re: **Site Servicing Plan Review**
Proposed Self Storage Development
75 Michael Cowpland Drive – Ottawa, Ontario

date: September 5, 2023

file: PG3798-MEMO.02 Revision 1

Site Servicing Plan Review

SHEET TITLE
GENERAL PLAN OF SERVICES

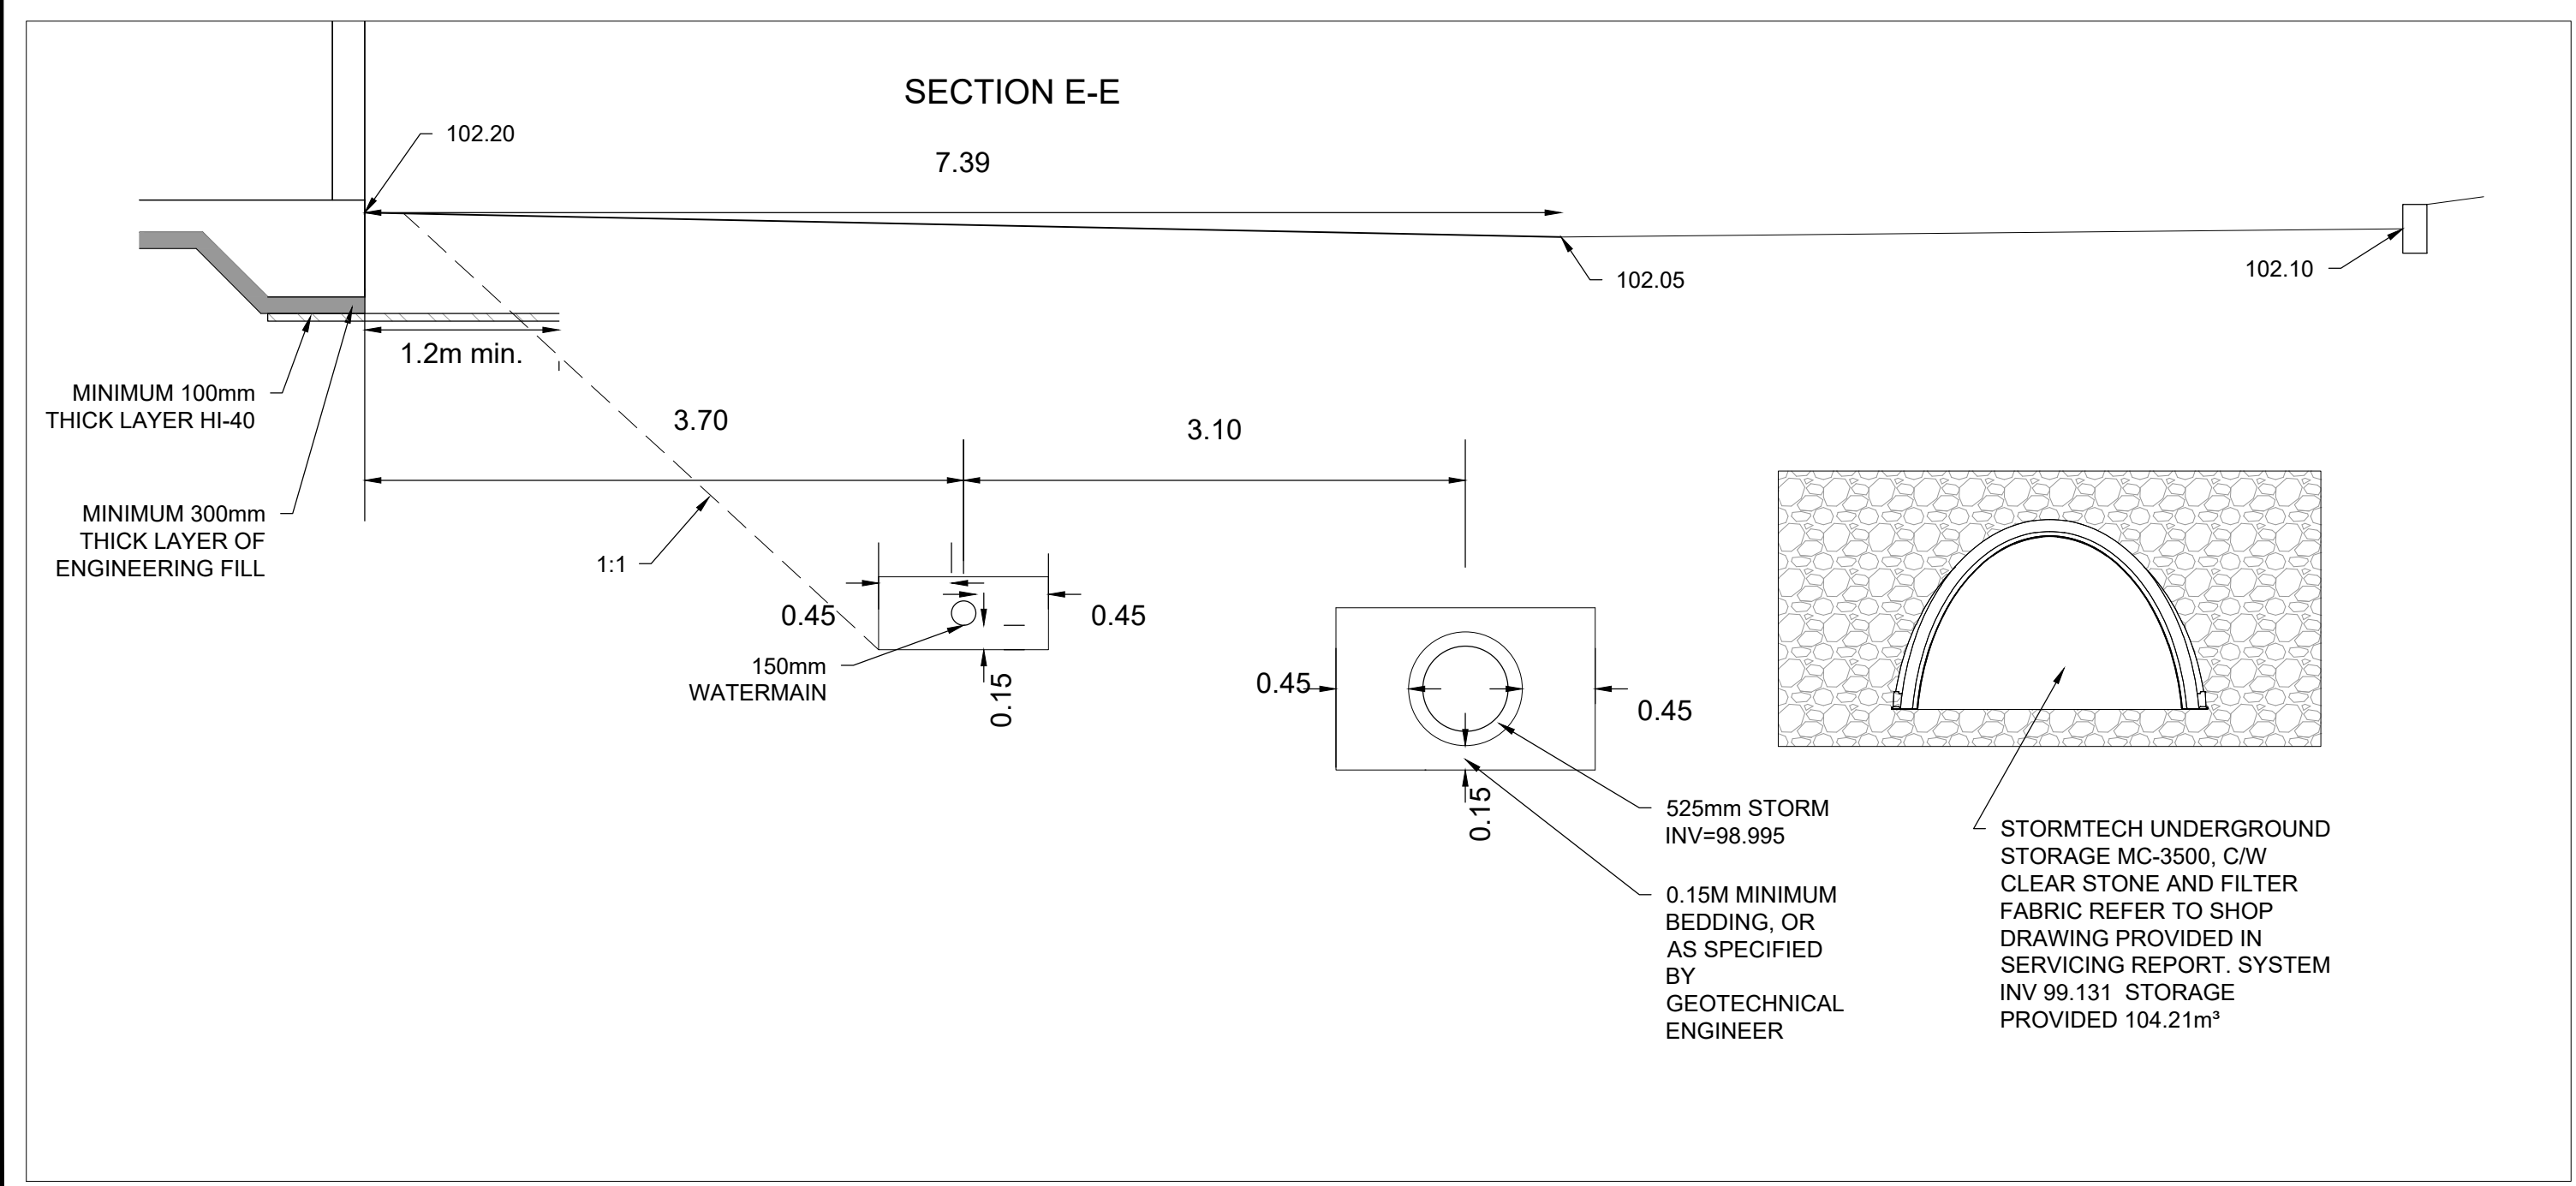
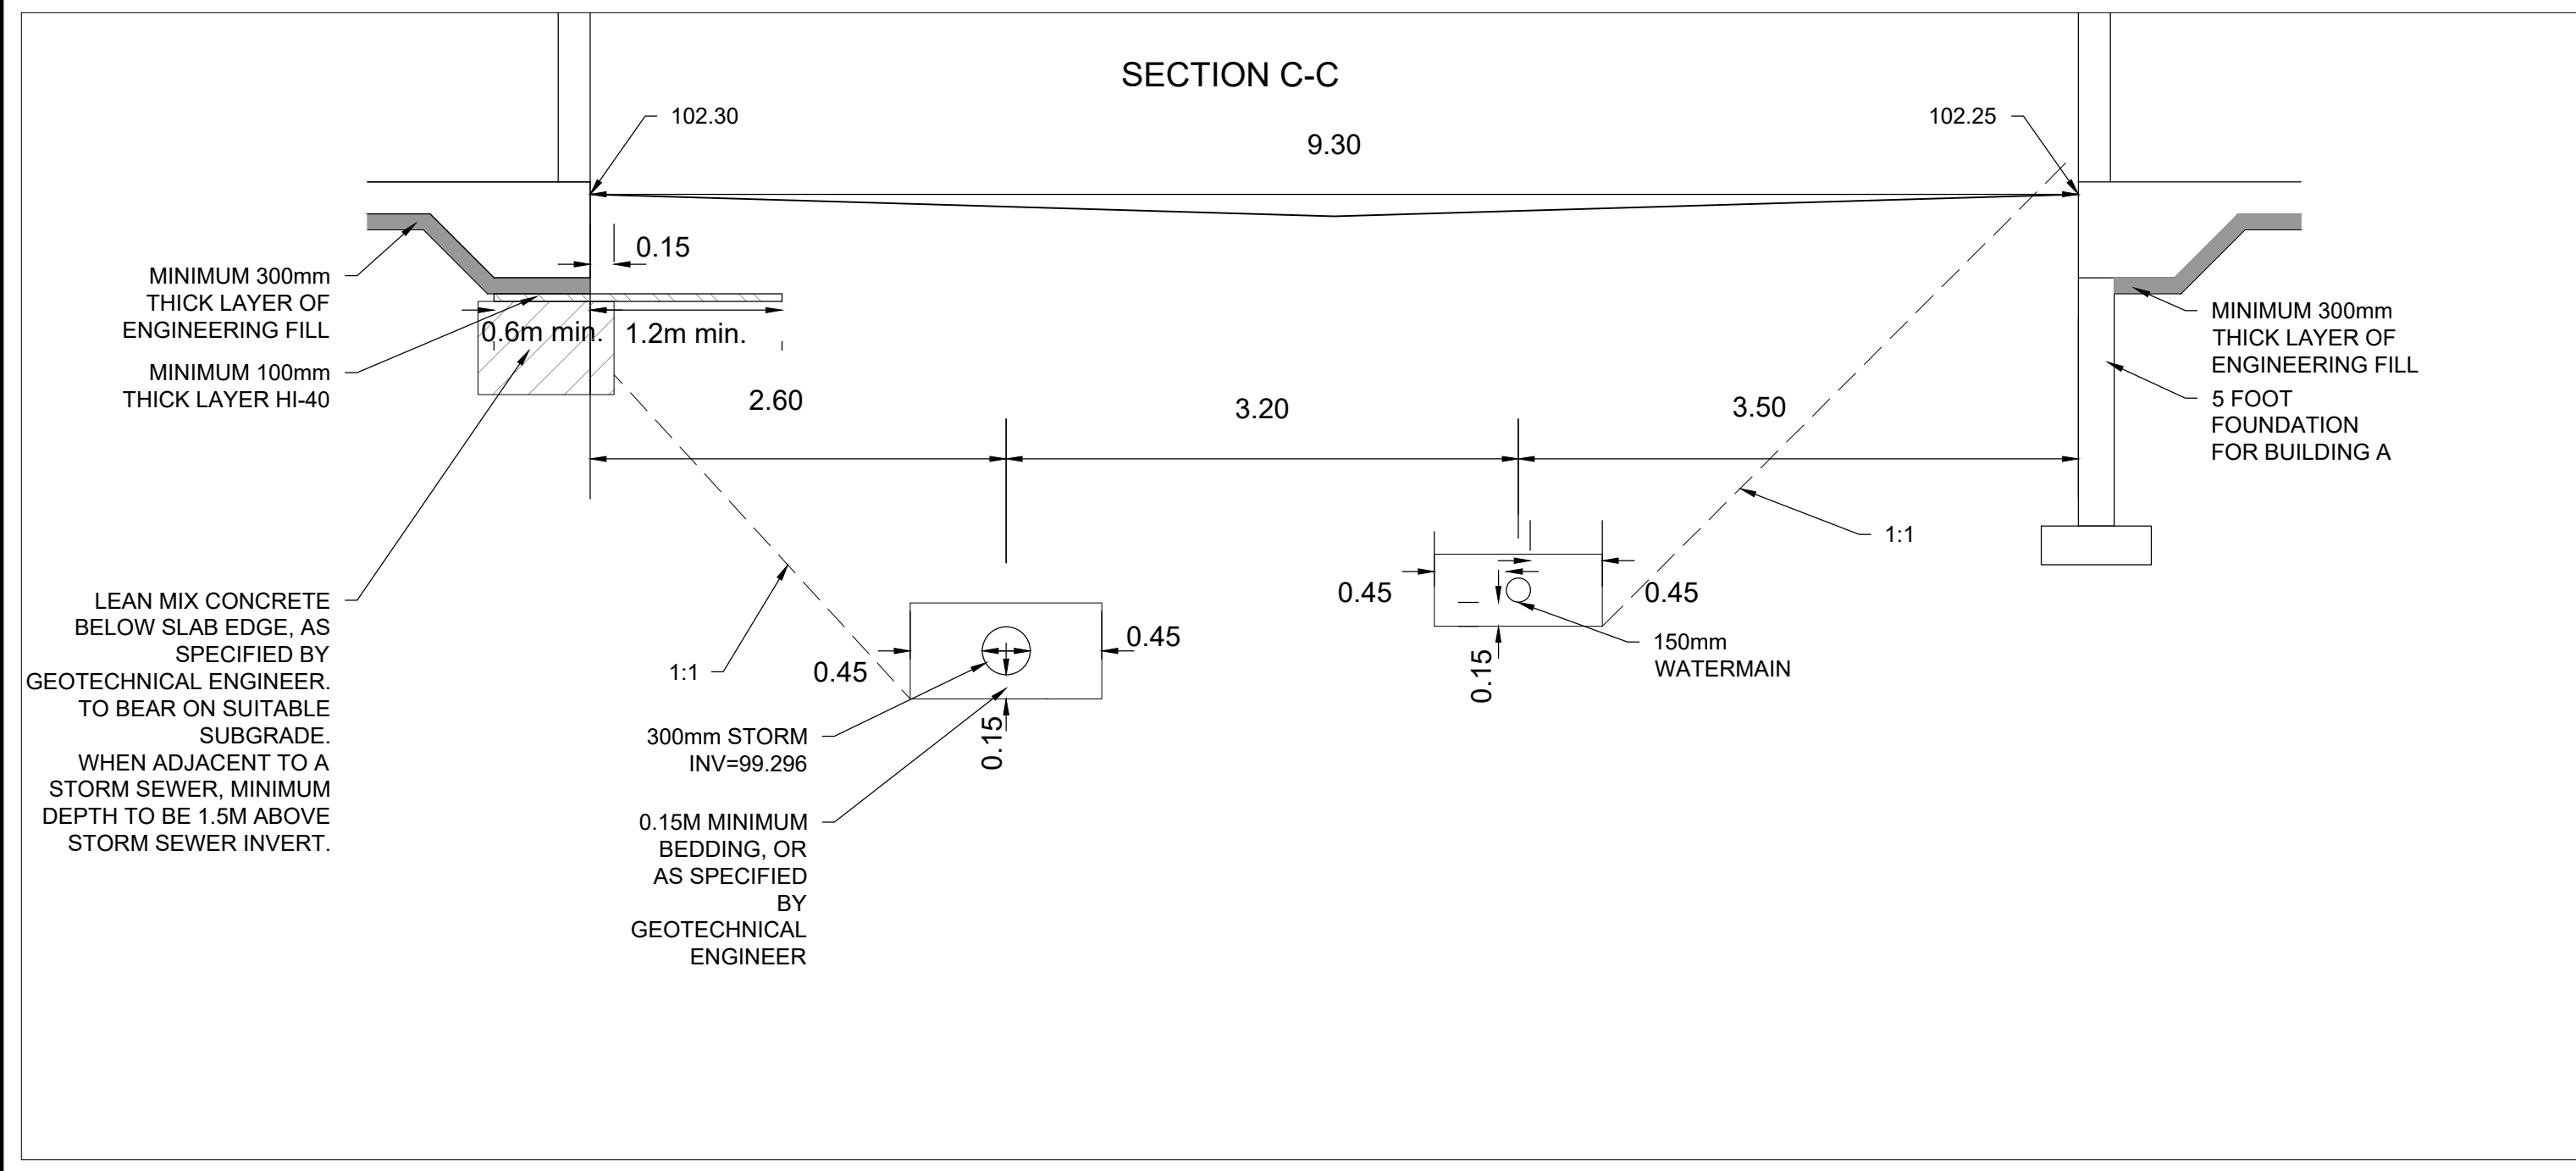
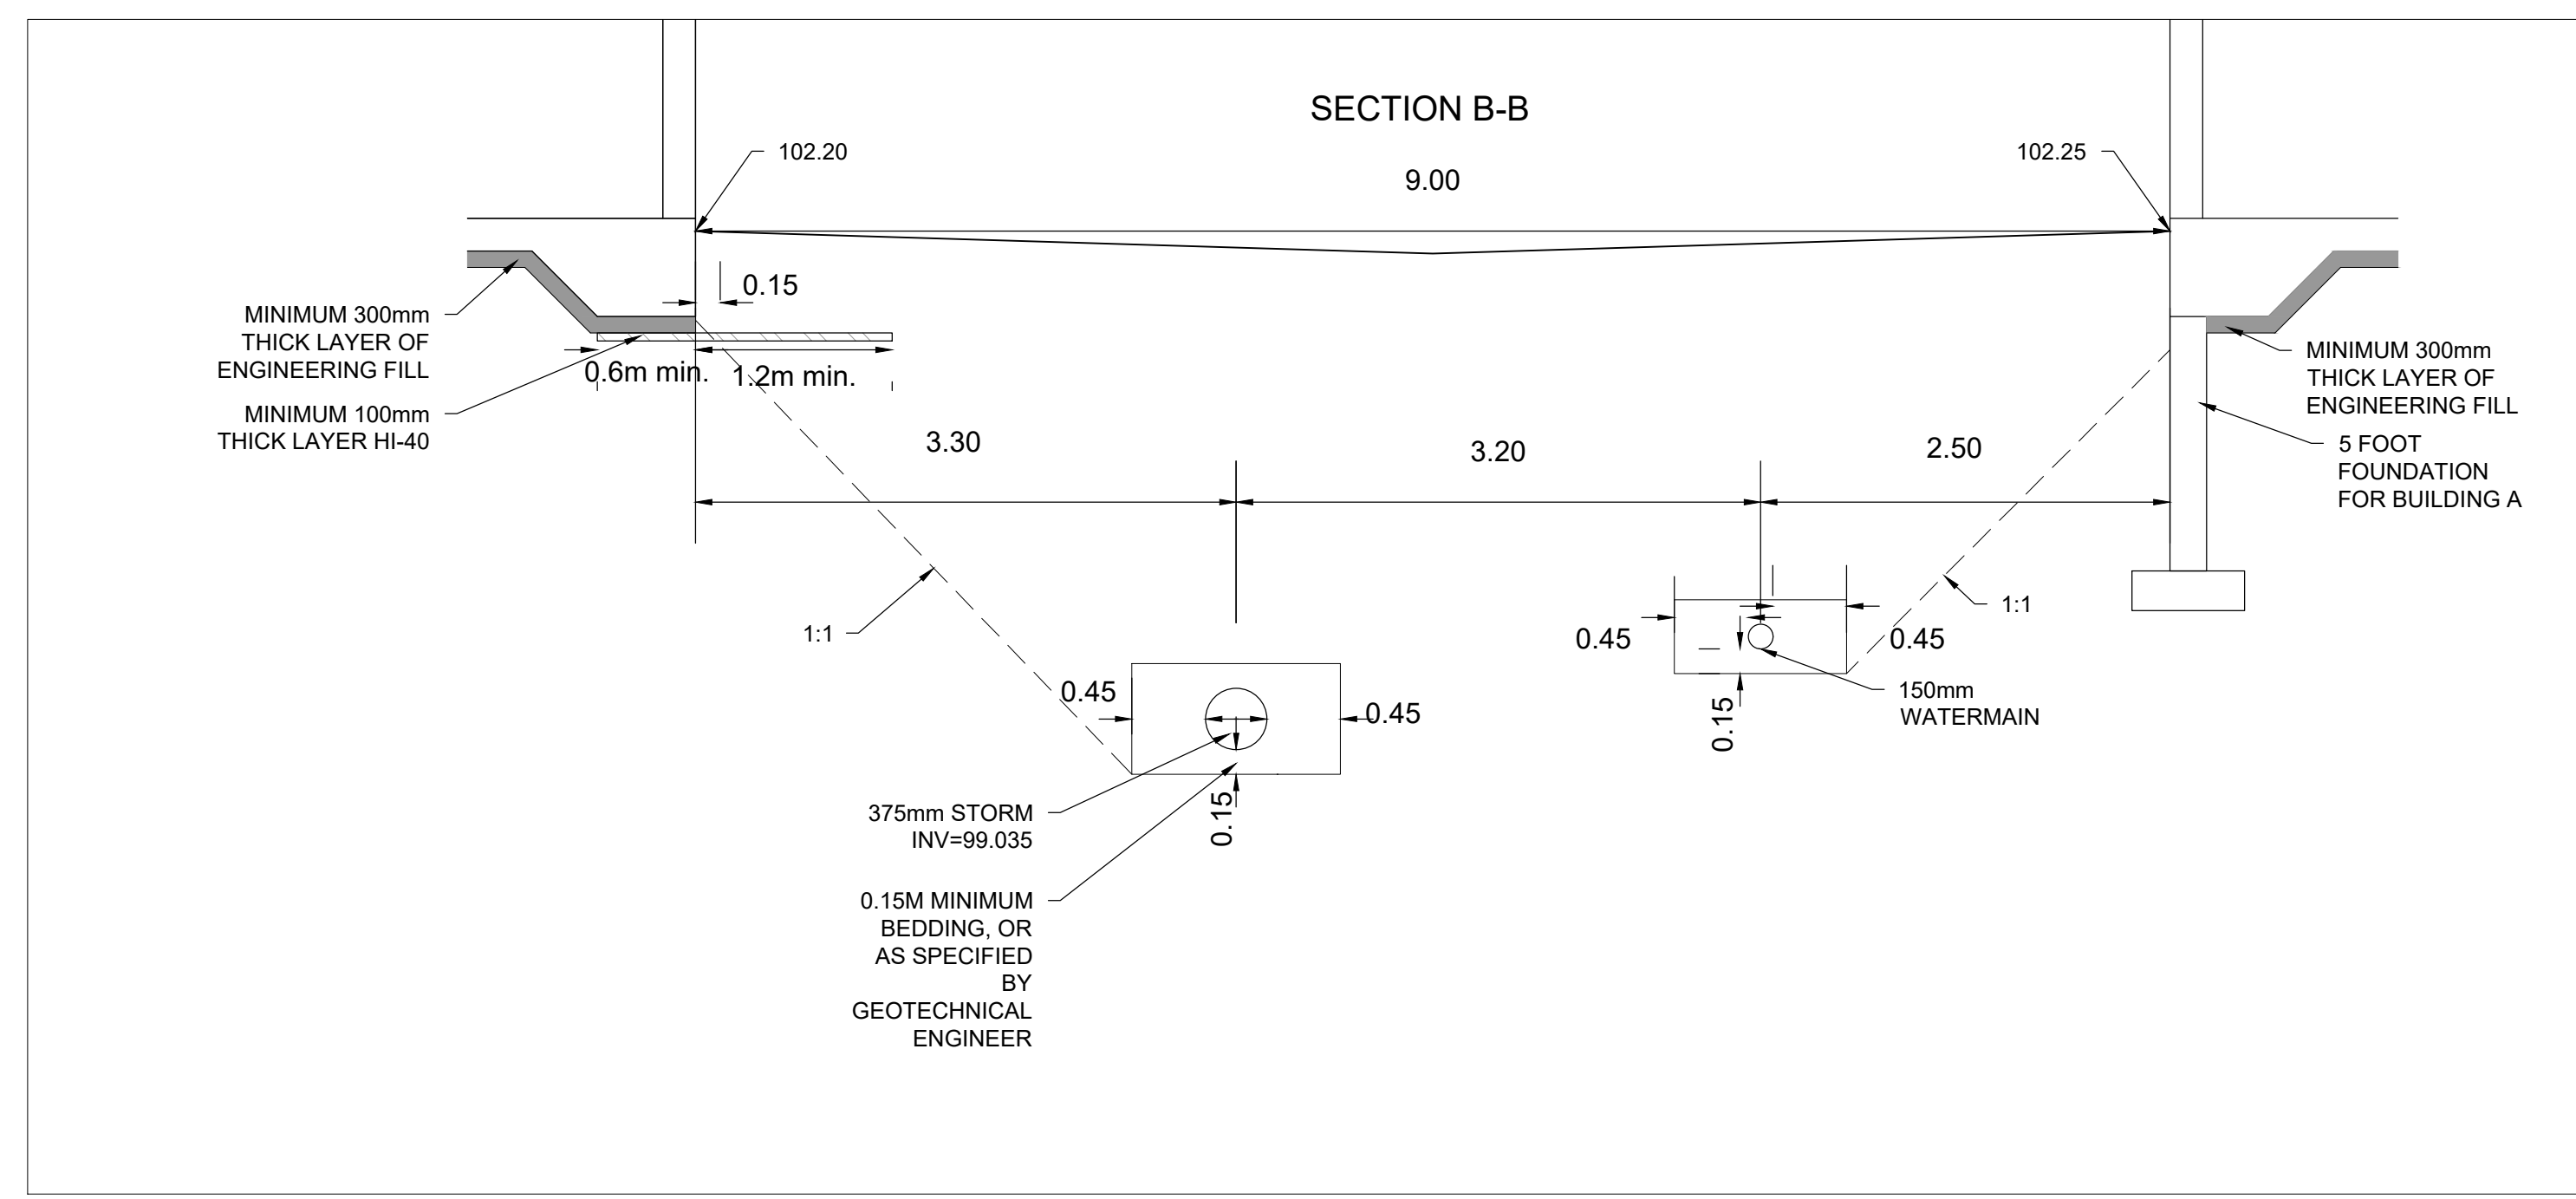
It should be noted that insufficient frost protection has been provided for several segments of the existing storm sewer services, mostly related to the pipes from catch basins tying into the main storm drain throughout the subject site. At these locations, the invert level of the storm sewer services are located within the frost zone (i.e. approximately 1.8 m below the proposed finished grade).

Due to the proposed grading and the addition of the proposed retaining wall, minimal frost cover is provided for the existing service alignments. Therefore, additional frost protection is recommended for these services.

It should be noted that the existing shallow services pipes along the north corner of the site will be subject to insulation due to the new proposed grading at the subject site. Depending on the soil cover above the invert level of the pipes, the following table indicates the minimum thickness of rigid insulation required to be placed directly above the obvert of the subject pipes. A minimum HI-40 rigid insulation panels should be placed directly above the existing pipes and should extend horizontally beyond the edges of the subject pipes as shown on *Figure 1 – Typical Rigid Insulation Detail* below.

It is recommended the near-vertical trenches extend a minimum of 150 mm horizontally beyond the overlying footing footprint. Based on our review, the lean-concrete trench detail has been incorporated satisfactorily into the above-noted site servicing plans with the exception of widening the trench a minimum of 150 mm beyond the face of the overlying thickened edge footing footprint.

Where the lean-concrete trenches will terminate within the frost zone for a heated building, it is recommended to extend a minimum 100 mm thick layer of HI-40 rigid insulation a minimum horizontal distance of 900 mm beyond the overlying building footprint. The location of this insulation is depicted in blue on *Figure 1 – Thickened Edge Slab Insulation Details and Plan* attached to this memorandum. Where the lean-concrete trench is anticipated to extend below frost zone for a heated building, the exterior building insulation has been omitted from the above-noted plan.

Table 1 - Rigid Insulation Recommendations for Storm Sewer Pipes with Reduced Soil Cover			
Thermal Condition	Soil Cover Provided (mm)	Insulation Dimensions	
		Thickness (mm)	Extension (mm)
Unheated	600 to 900	125	Extend 1200 mm horizontally beyond edge face of the sewer
	900 to 1200	100	Extend 1200 mm horizontally beyond edge face of the sewer
	1200 to 1500	75	Extend 900 mm horizontally beyond edge face of the sewer
	1500 to 1800	50	Extend 600 mm horizontally beyond edge face of the sewer
	1800 to <2100	25	Extend 300 mm horizontally beyond edge face of the sewer

All rigid insulation should consist of either Dow Chemical High-Load 40 (HI-40) or equivalent other approved by Paterson. The placement of all insulation within the service trenches must be reviewed and approved by Paterson personnel at the time of construction.
